Huntlee New Town Residential Subdivision Stage 1 (MP 10_0137 MOD 11)

The Biodiversity and Conservation Division (BCD) of the Department of Planning Industry and Environment (the Department) has reviewed the submission for Modification 11 'Section 4.55(1a) Modification Application MP_10_0137 (Mod 11) Huntlee New Town, Branxton' prepared by Ethos Urban, and dated 7 November 2019. BCD understands Mod 11 involves the creation of one additional residential lot within residential Stage 16 (R16) as a result of the subdivision of superlot 222, and one additional Town Centre commercial lot within TC1, delays in the timing for the road upgrade, minor road and lot boundary alignment amendments, and a request to change conditions of consent.

BCD's detailed comments

STORMWATER MANAGEMENT
PLAN
GENERAL ARRANGEMENT

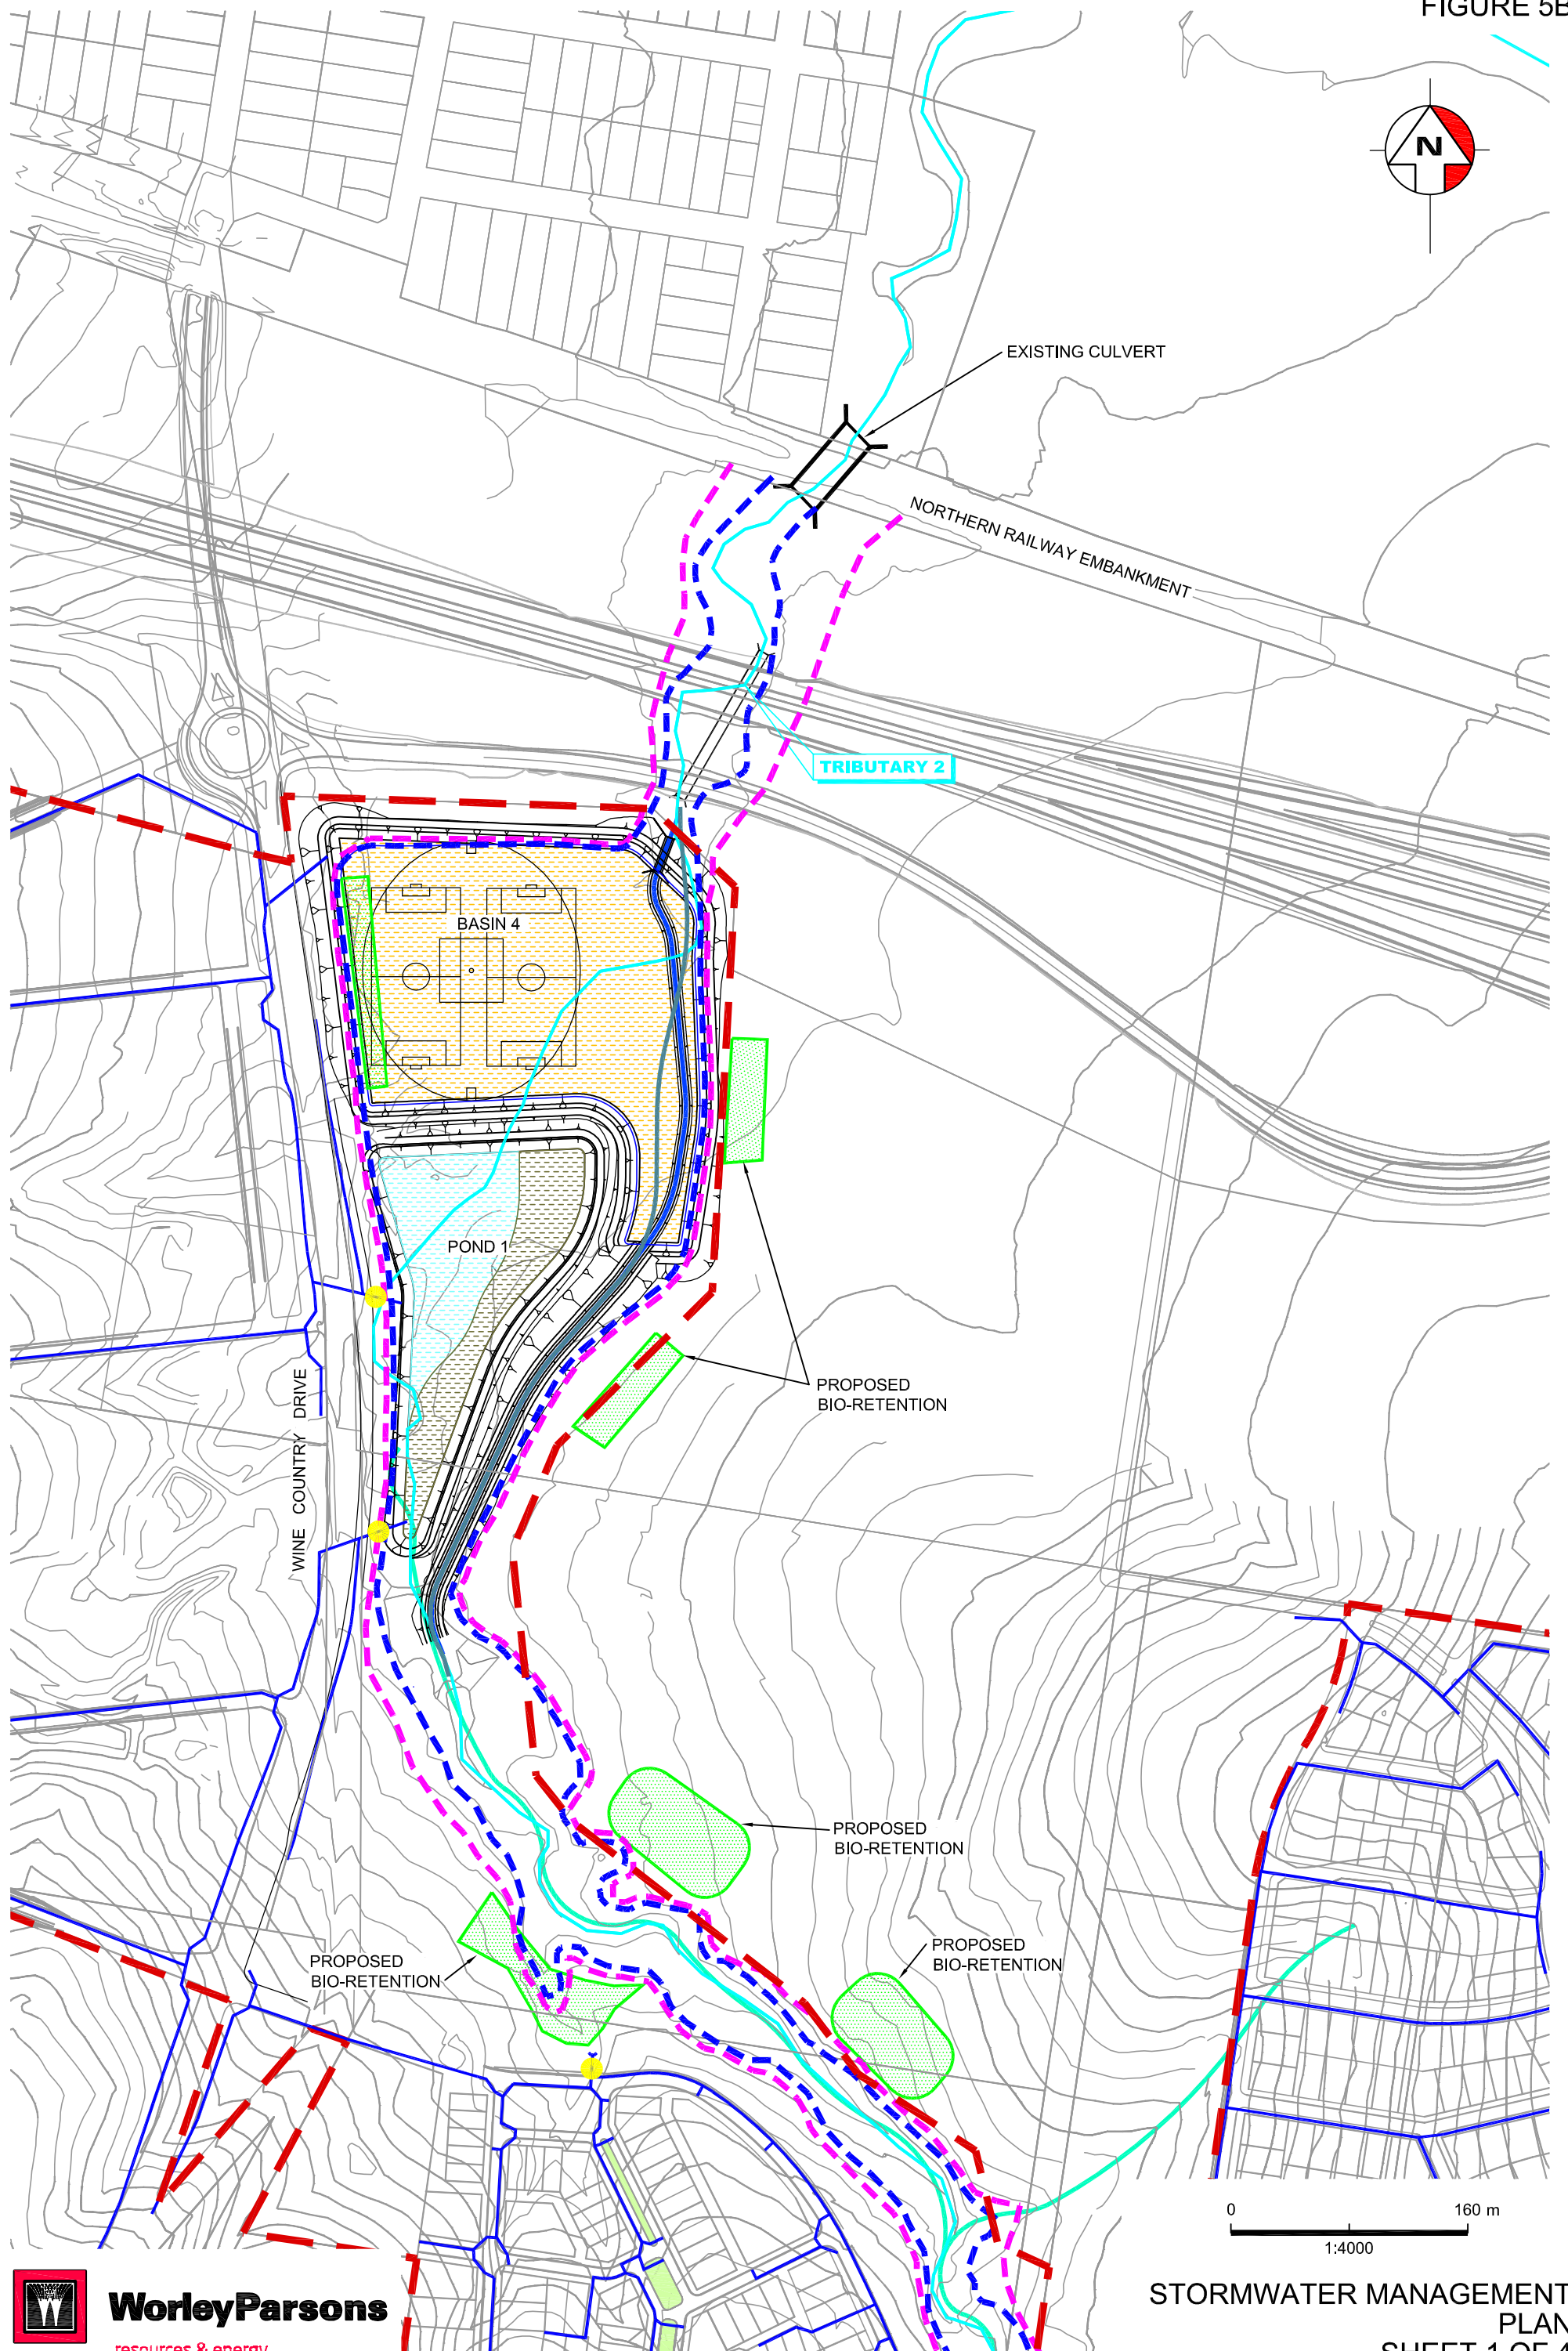
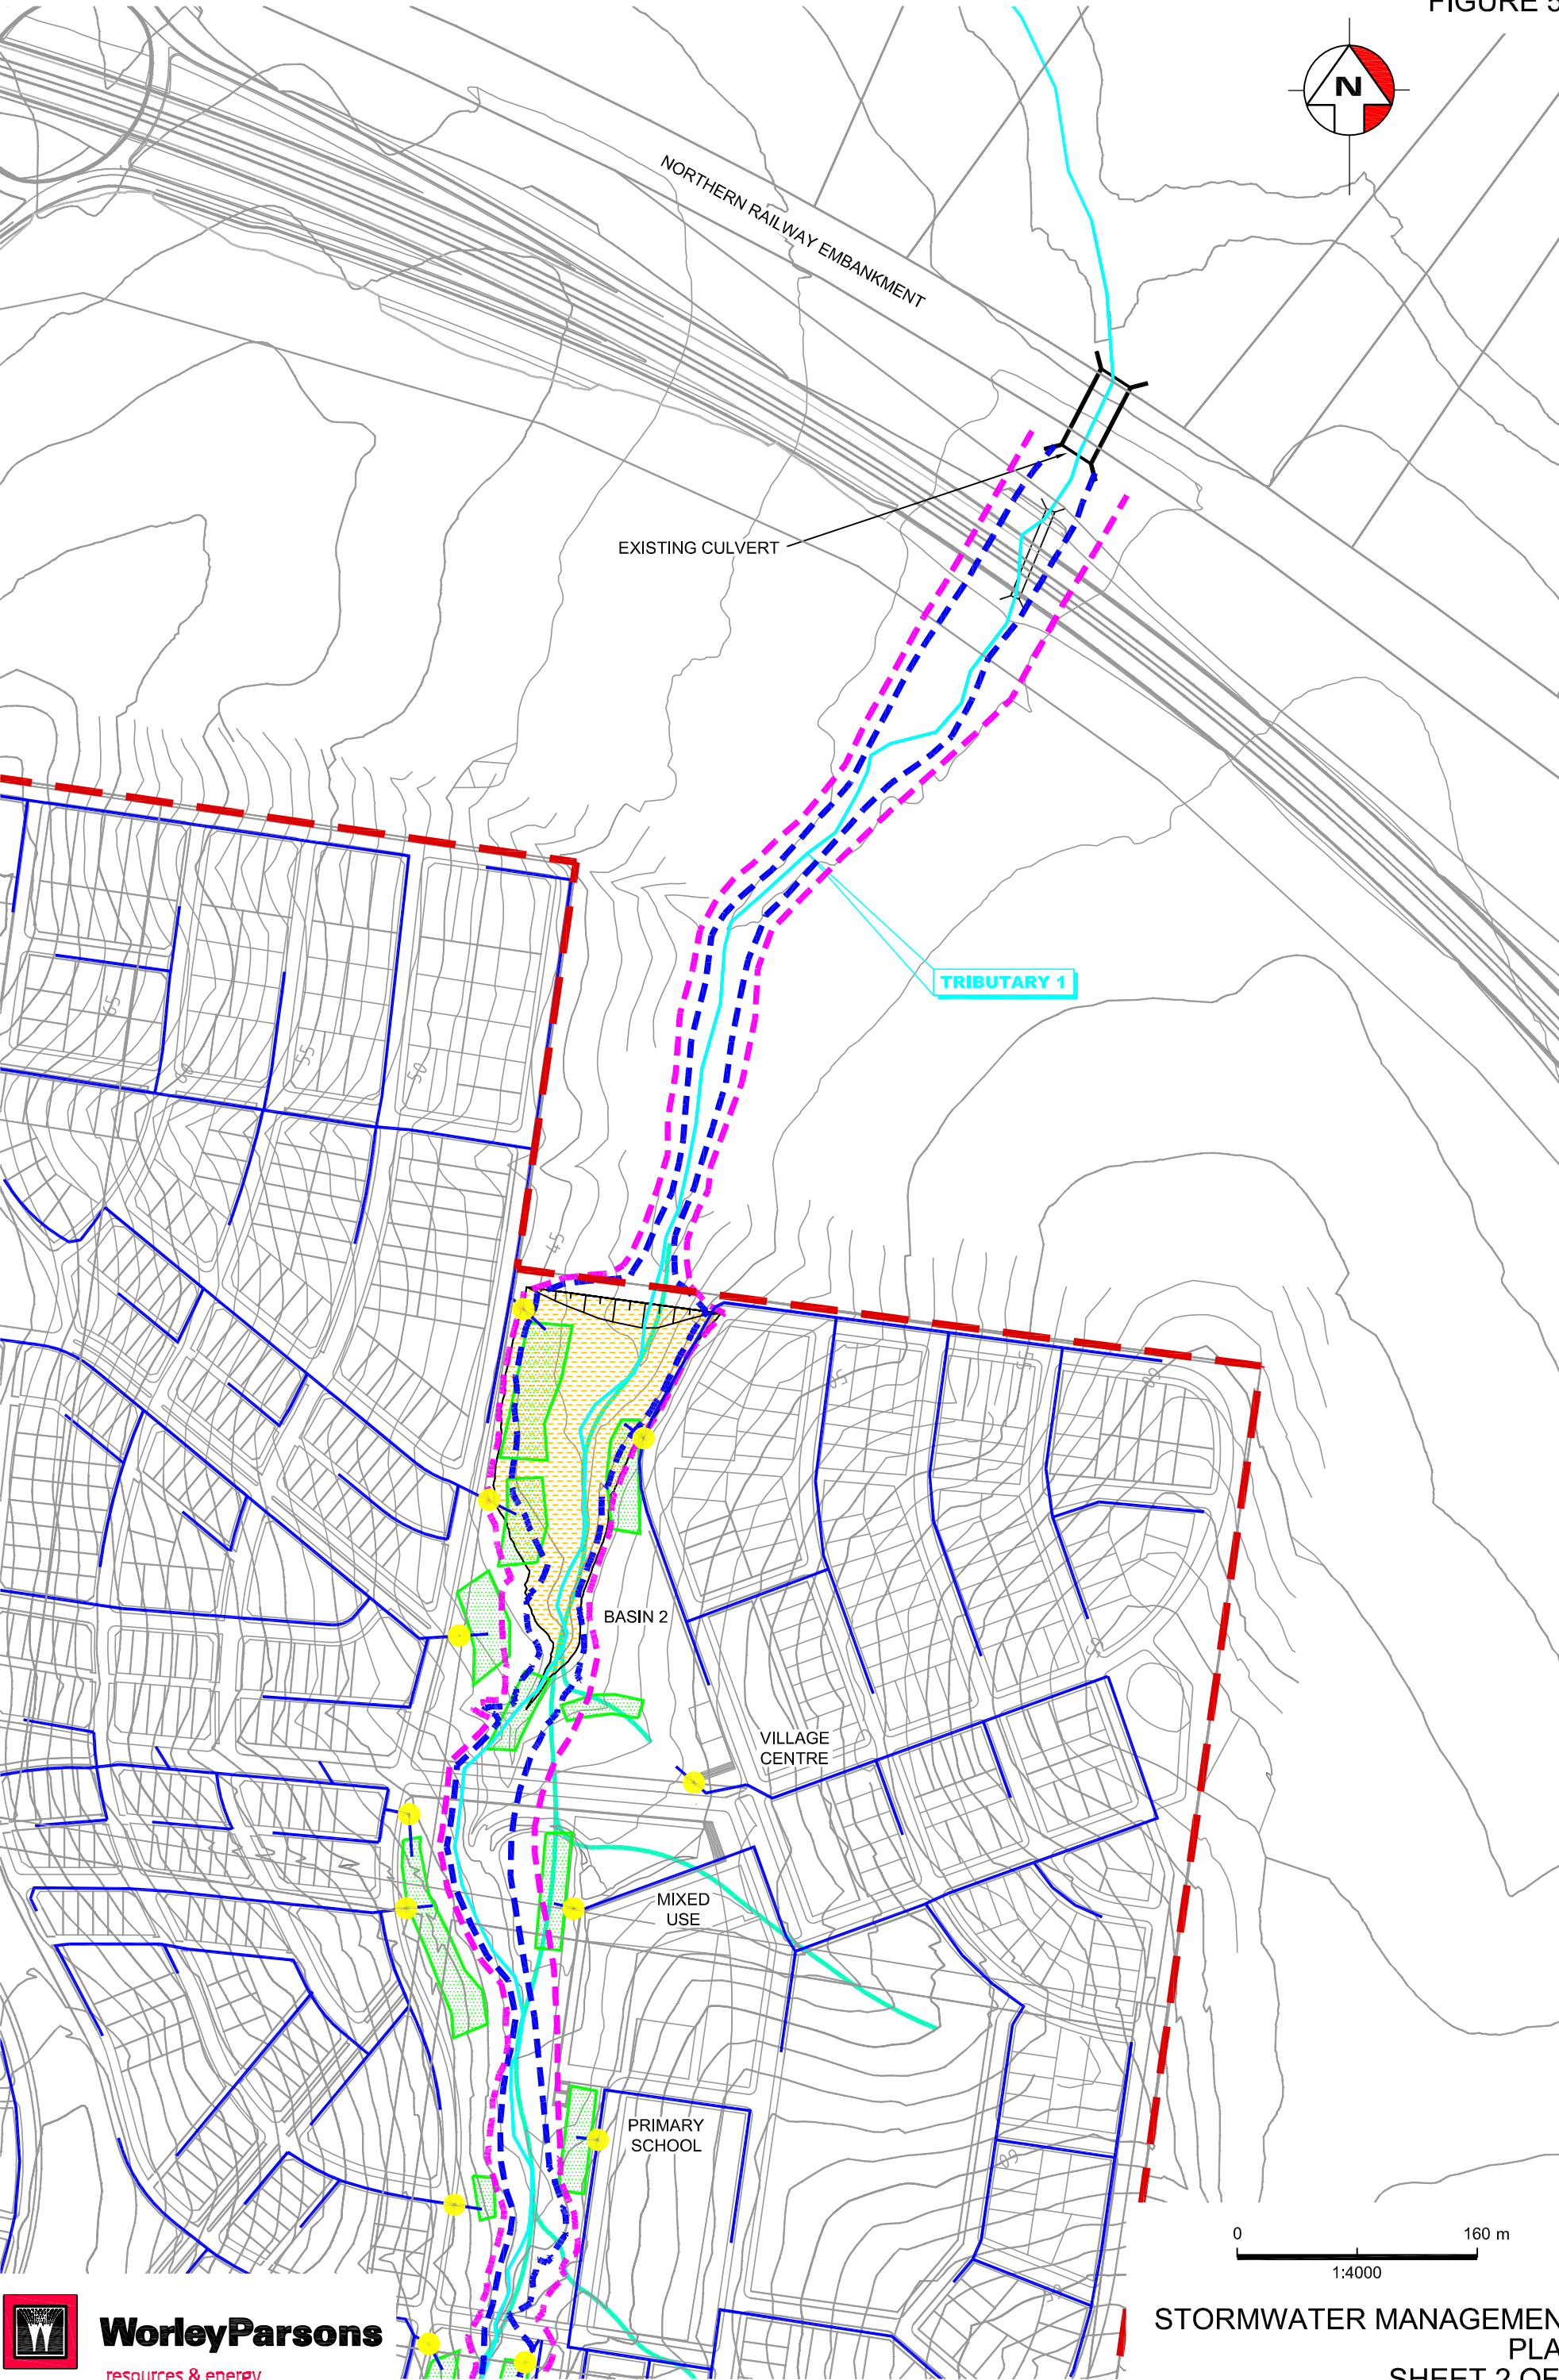
Mod 11 notes that proposed Amendment 1 and Amendment 53 impact on proposed on-site detention locations. The requirements for on-site detention are currently being reviewed and designed by Northrop Engineers. Engineering design work as part of Mod 9 indicates that larger basins than those originally planned are required to manage flows. It is understood that Mod 9 has not yet been approved.

Subdivision mapping is to show location and size of water quality and on-site detention basins. Confirmation through preliminary design is required to confirm that sufficient land area remains to accommodate the on-site detention structures.
